KITTITAS COUNTY

MEMORANDUM

TO: All Staff
FROM: Public Works Plan Review Team
DATE: August 12, 2024
SUBJECT: SP-24-00009 Black

BLACK SHORT PLAT

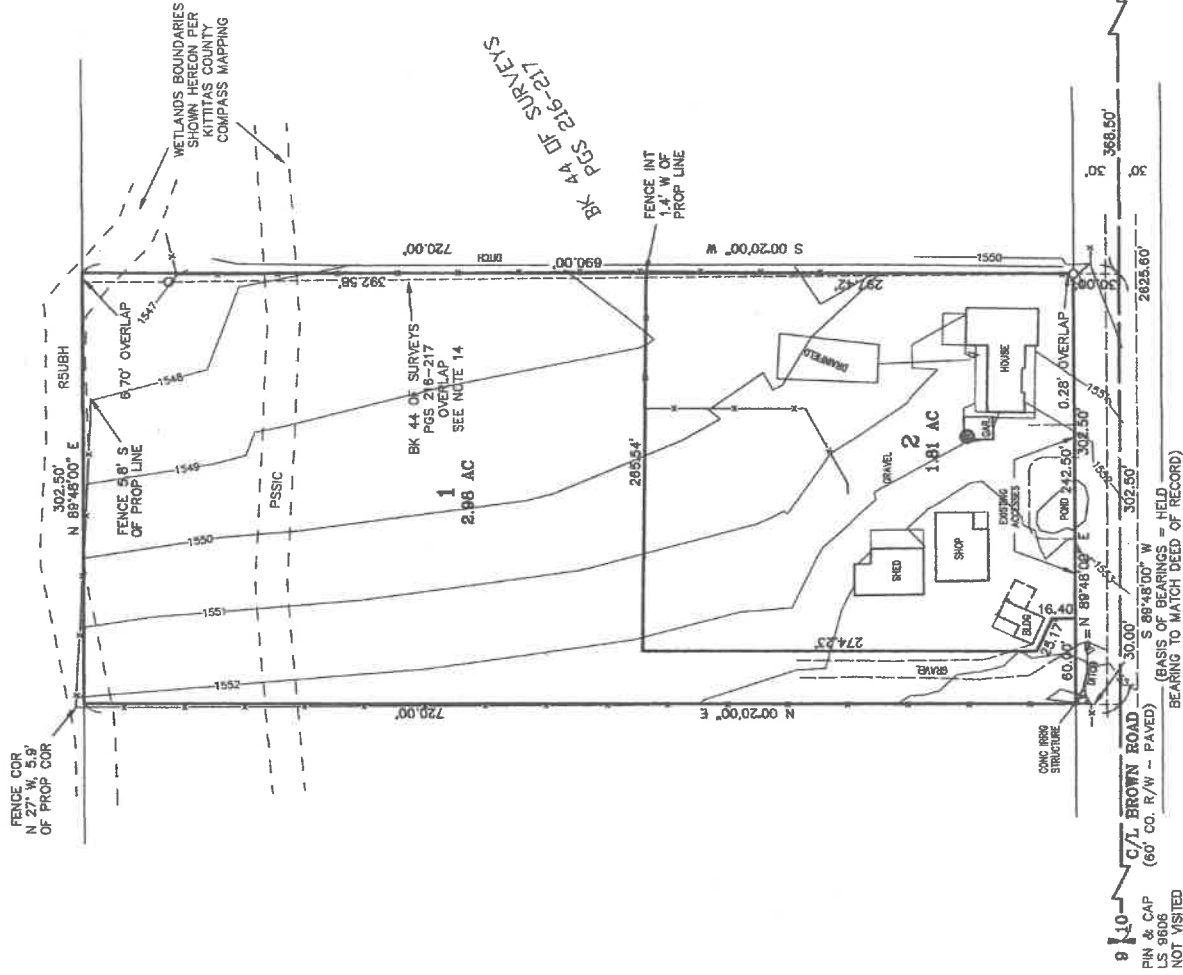
SURVEY	<p>The following review applies to the Prelim Short Plat only. Additional comments may address final submittal.</p> <ol style="list-style-type: none">1. Submittal does not meet the requirements of WAC:332-130-145 Topographic elements on maps.2. Proposed Lot 1 does not appear to meet dimensional requirements per KCC 17.29.090.3. Please show building offsets for the building adjacent to the proposed new boundary, to ensure it meets the 5' setback per KCC 17.29.060. <p>OF NOTE Lot closures were not reviewed as part of this submittal. Given the simplistic nature of the division, lot closures are not required. Title report was reviewed as part of this submittal. Ownership and legal description are fine.</p>
